CITY OF ALBUQUERQUE

April 2, 2024

**RE: 12728 San Jacinto Ave NE
Grading and Drainage Plan
Engineer's Stamp Date: 02/21/24
Hydrology File: K22D066**

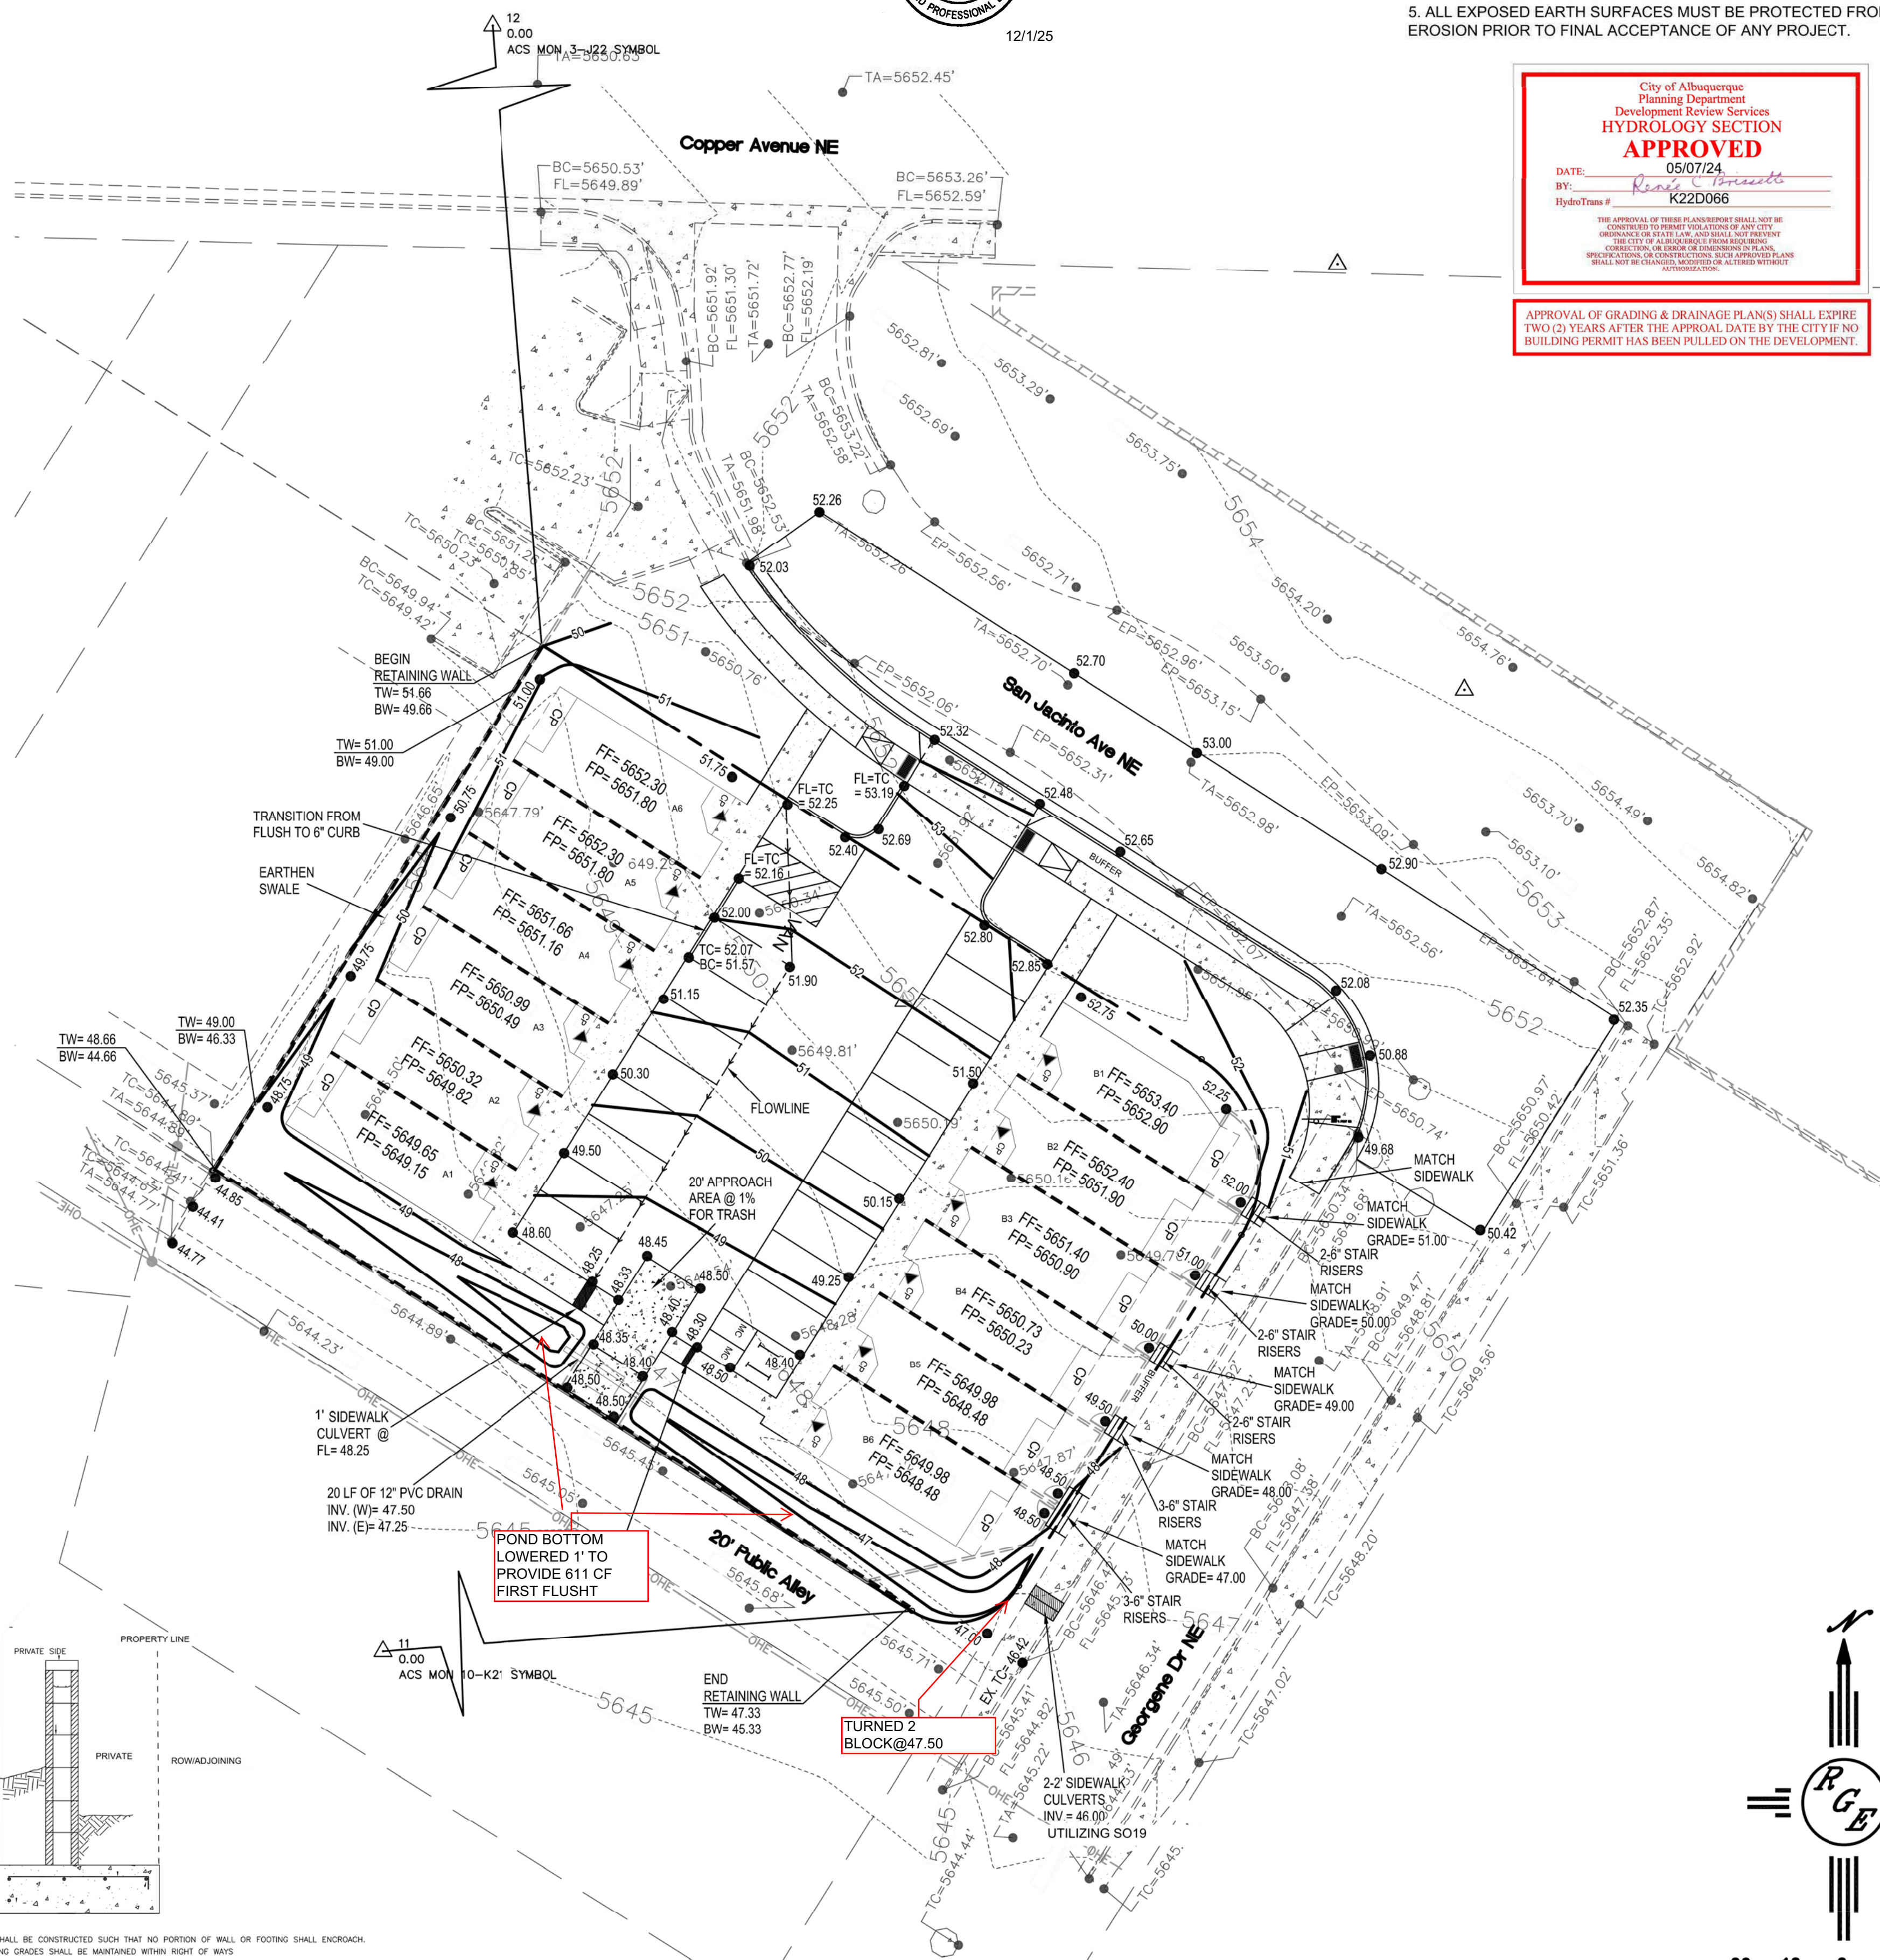
Based upon the information provided in your submittal received 03/25/2024, the Grading & Drainage Plan **is not** approved for Building Permit and Grading Permit. The following comments need to be addressed for approval of the above referenced project:

1. Since the project drains from the San Jacinto Ave NE to the 20' public alley, please bring the existing alley up to City standards per CoA Drawing 2411.

I think that this will be more cost effective than building a retaining wall and importing select fill to go against the natural grades and drain to San Jacinto Ave.
